CITY OF PORTLAND

September 27, 2004

RE: 158 Grant Street – 053-C-010 – R-6 Zone – application # 04-1306

DRAWING NUMBER: A-1

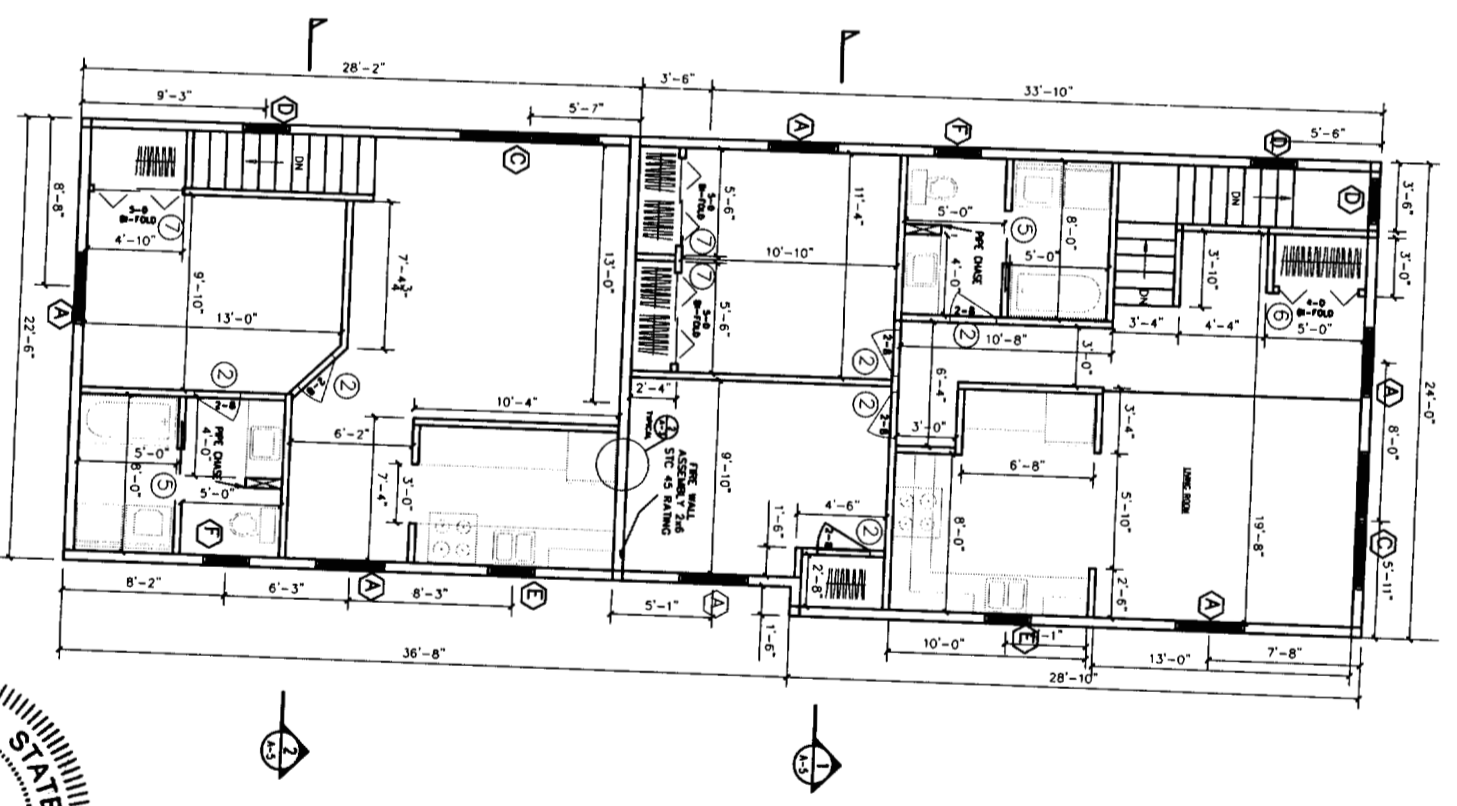
Section 14-136(a)2 of the ordinance requires that any alteration to a multifamily dwelling shall not result in any existing dwelling unit being reduced in size to less than one thousand (1,000) square feet of floor area. Your proposal shows that both existing units will be reduced to well under one thousand square feet.
